**Consultation Response from KC, Conservation & Design**
**2022/92081 Land at, Huddersfield Road/Leeds Road, Birstall, Batley, WF17 9AA**
**Demolition of existing buildings and erection of retail food store with associated parking and landscaping**
**Date Responded:**
**Responding Officer:**
**Responding Ref:**

Title
Proposed Elevations & 3D Views

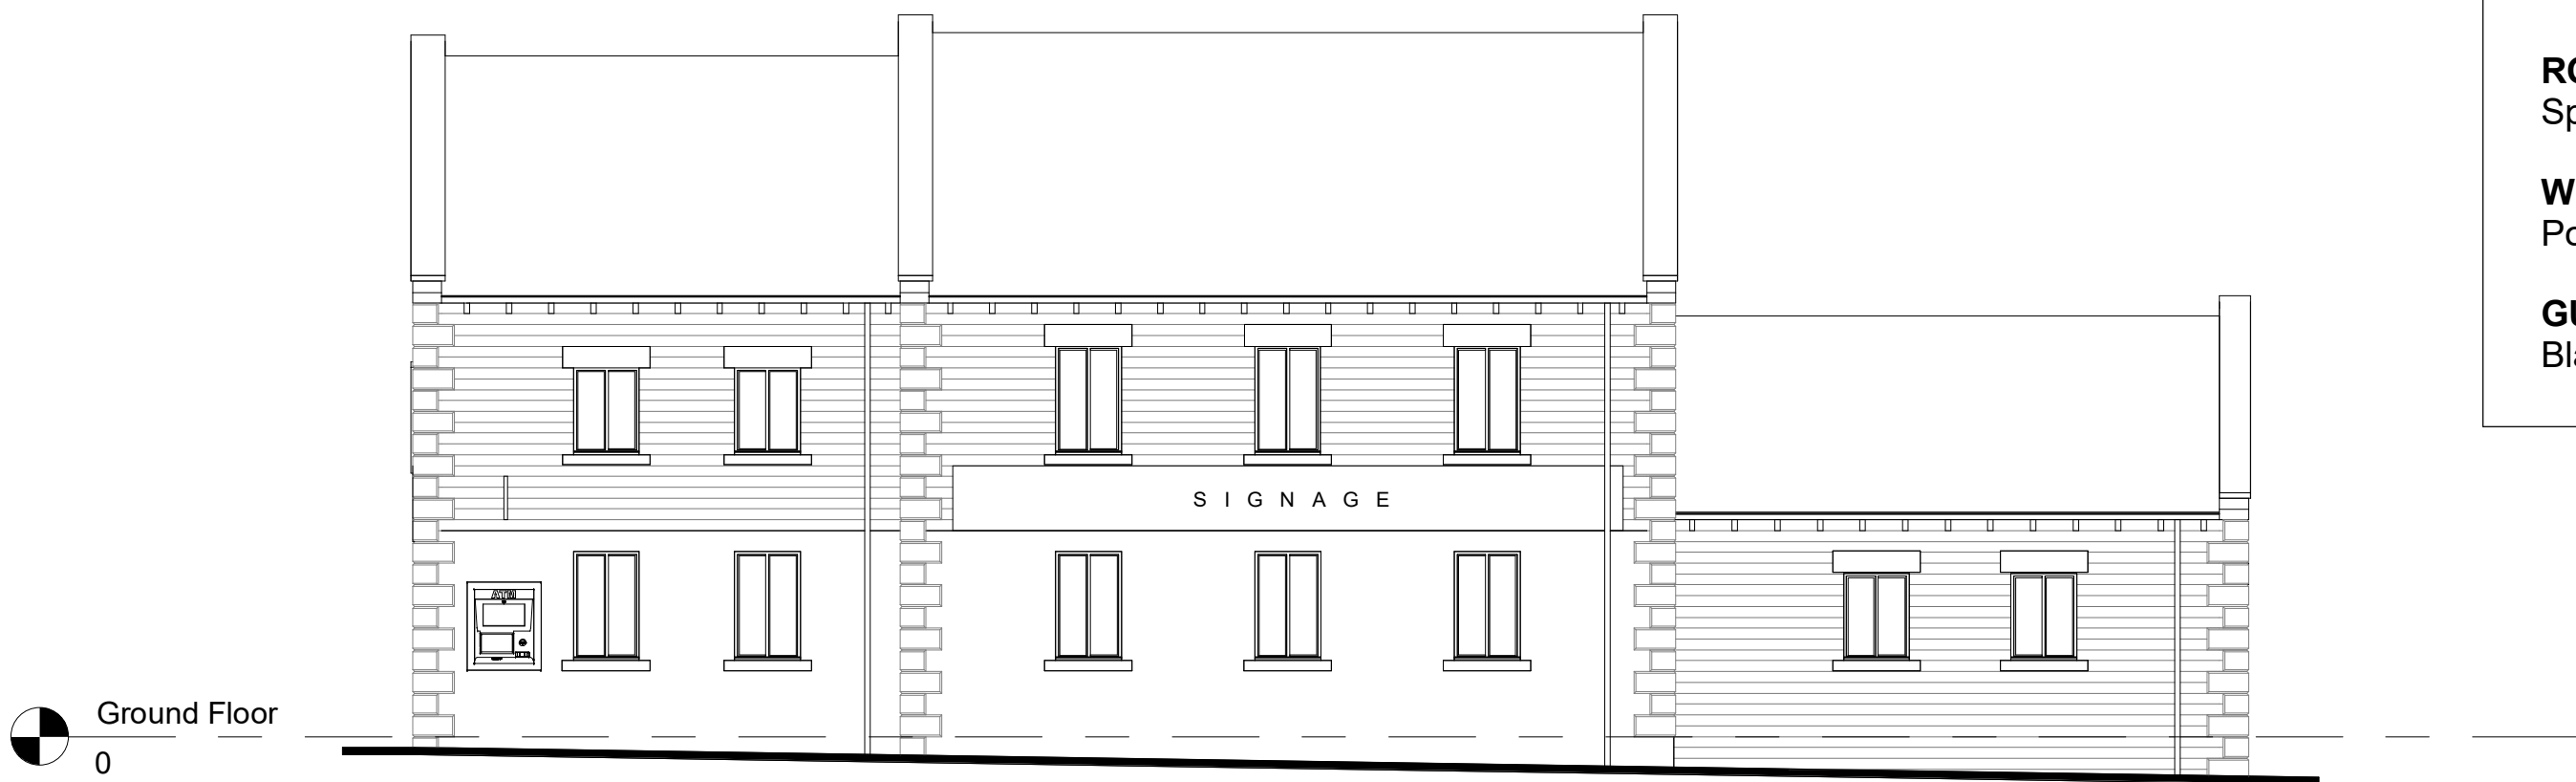
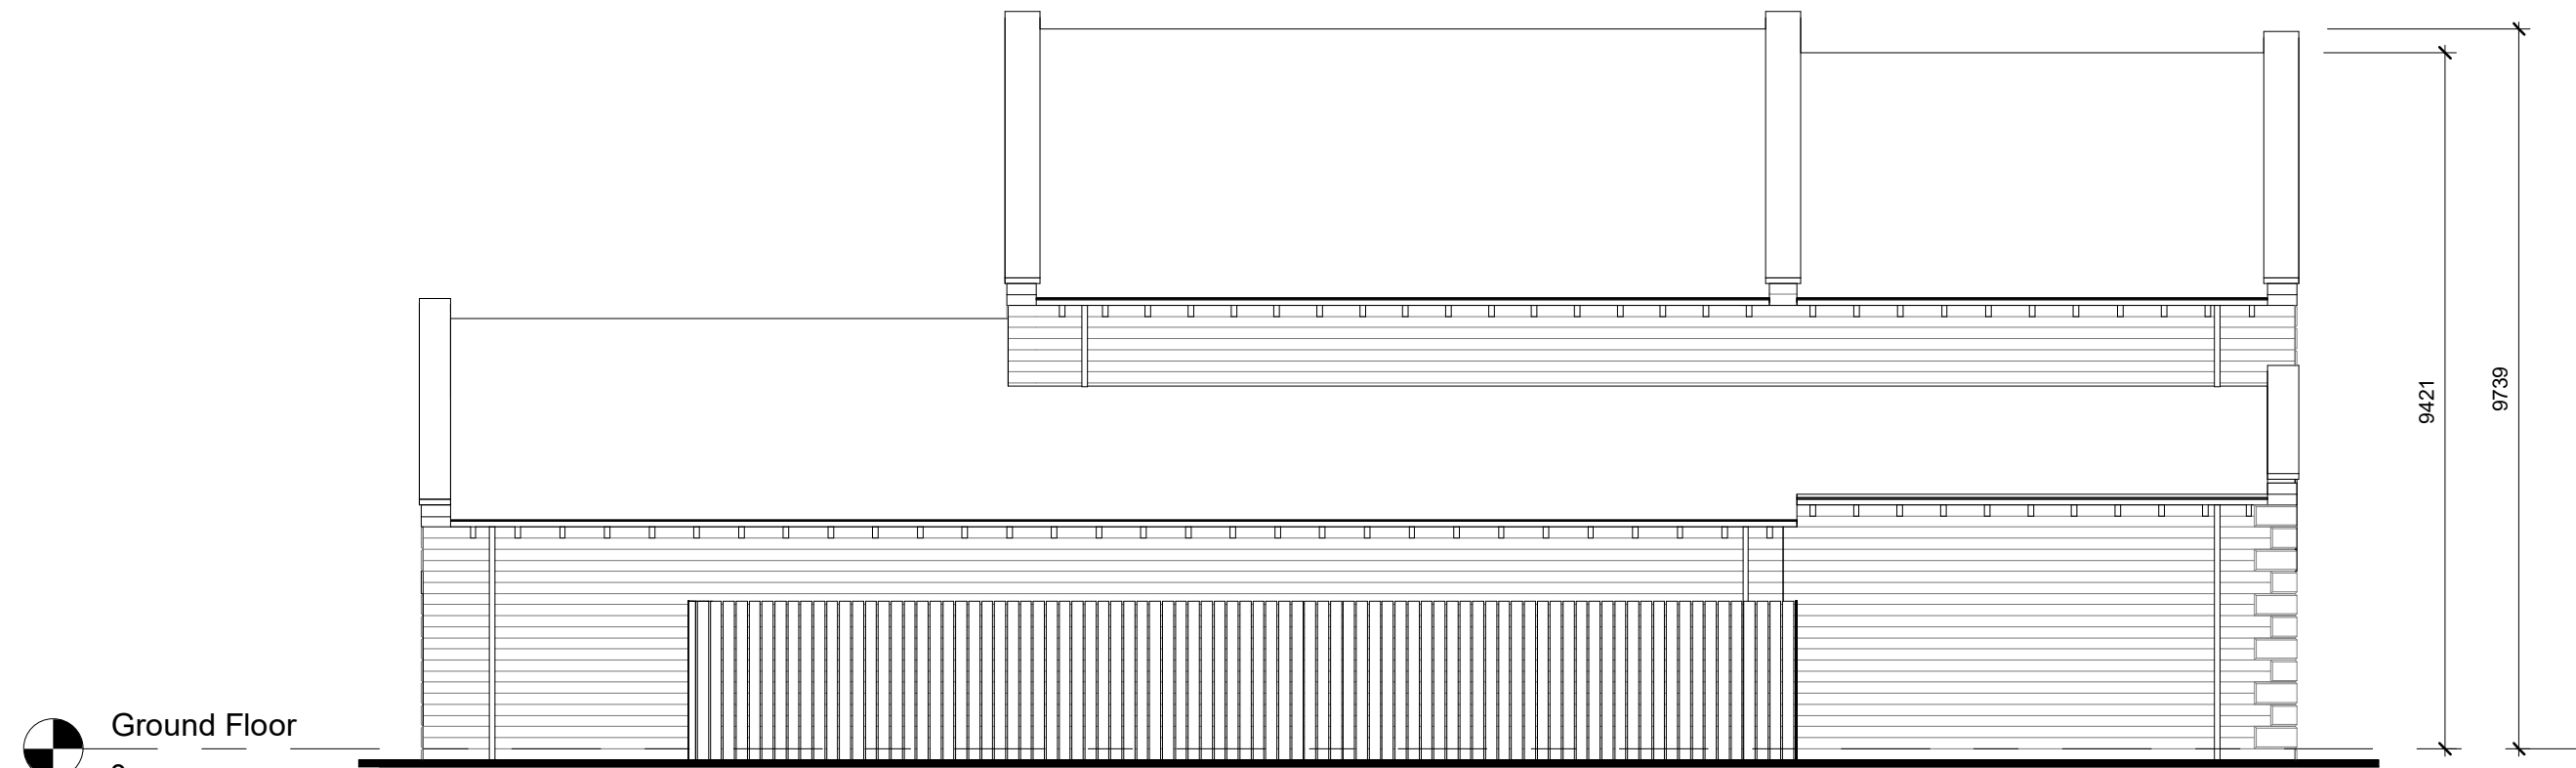
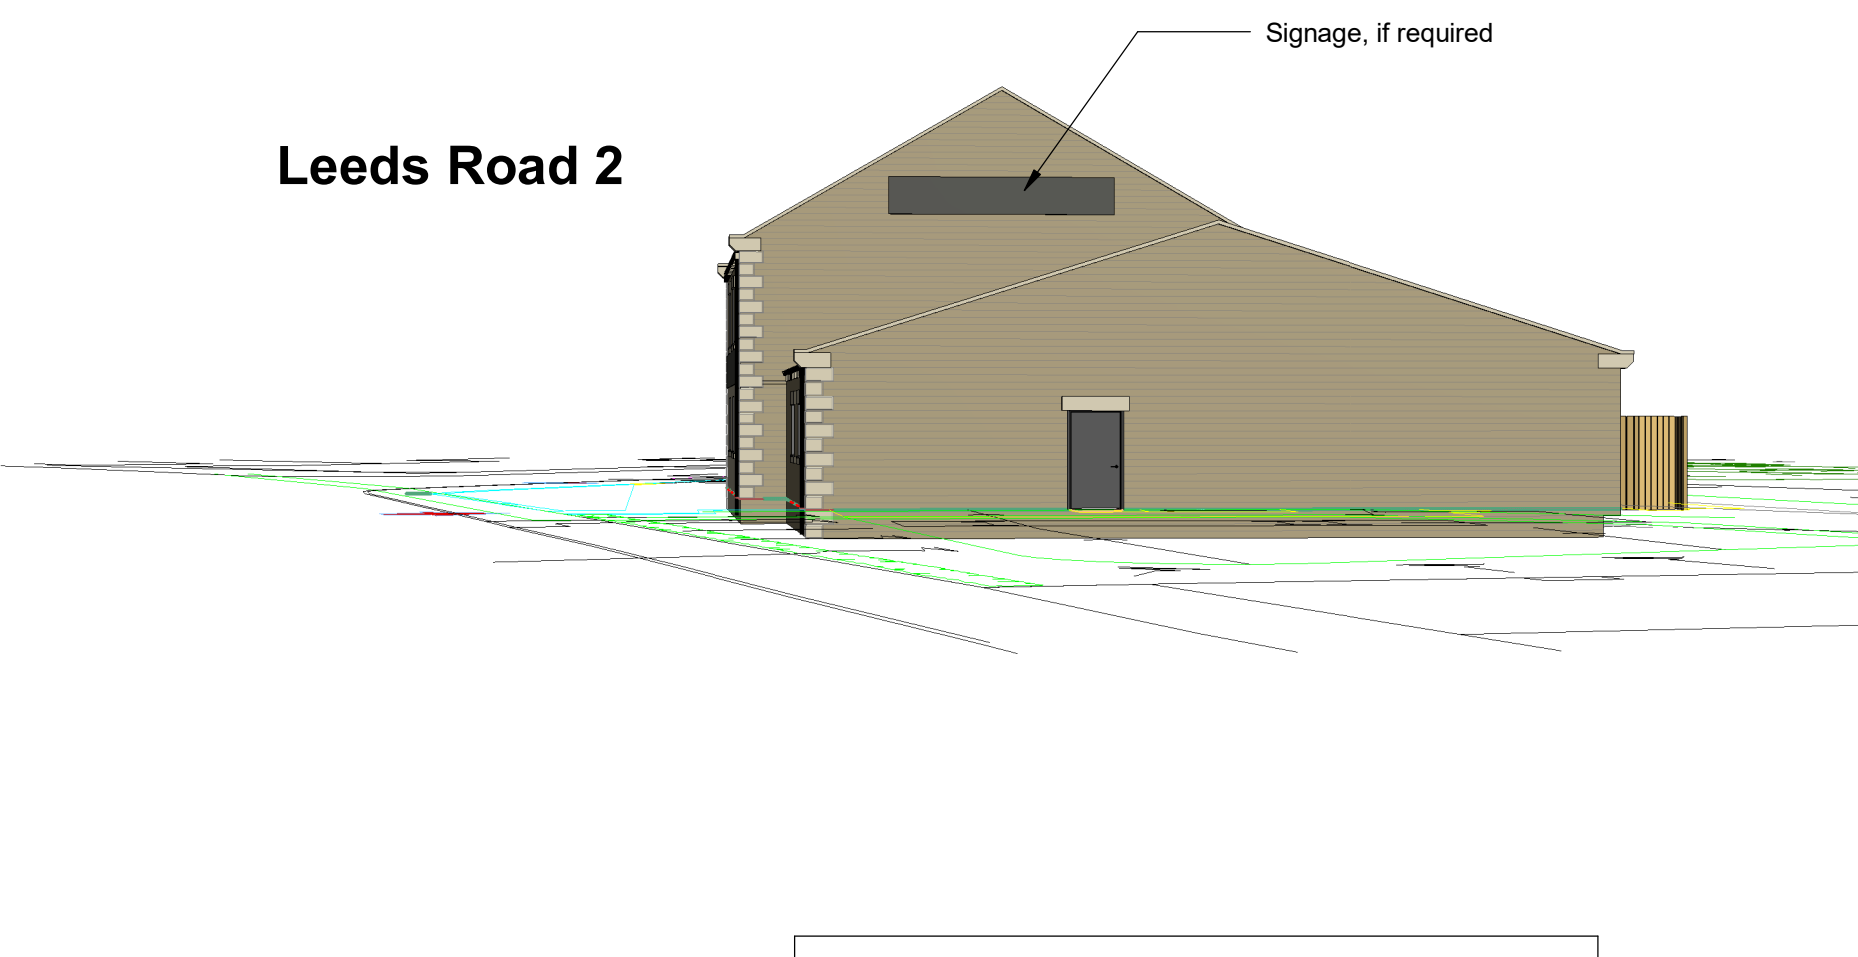
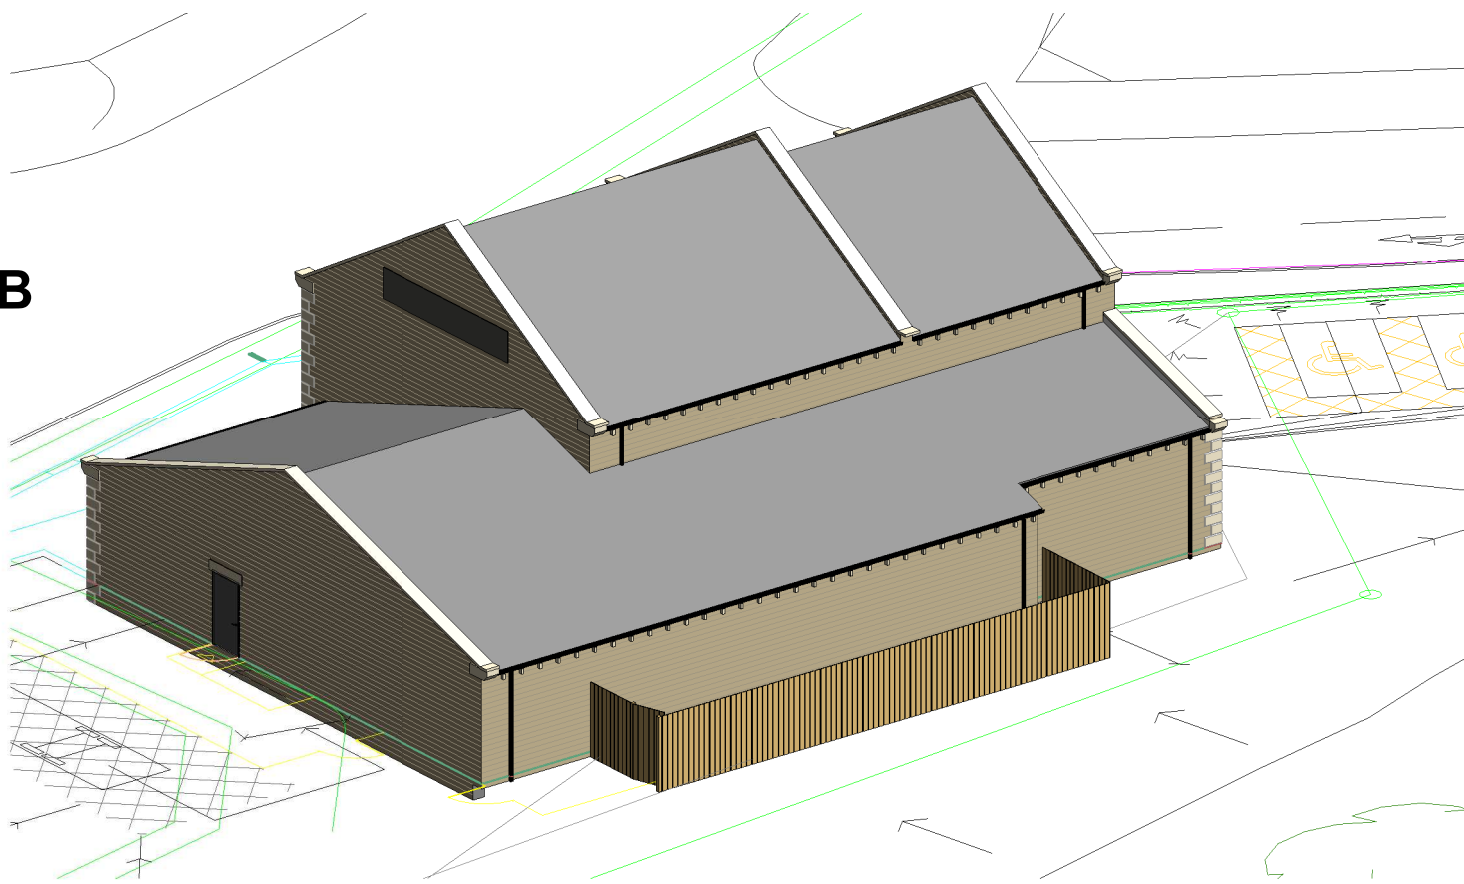
We do however have concerns in respect to the detail of the proposed replacement building. We consider that the building should be exclusively constructed from coursed, or hammer dressed stone, no use of ashlar, which is not characteristic of the area. We are also not supportive of the use of the ashlar quoins.

The roof should be amended for it to be finished in stone slates apposed to blue slates, which are not representative of the character of the area.

To the right-hand side of the elevation, it is proposed to step down from two stories to a single storey. Give the character of the existing building, we consider that the two-storey element should be continued along. This would still allow the single storey lean-to at the rear but would retain the frontage in the street scene.
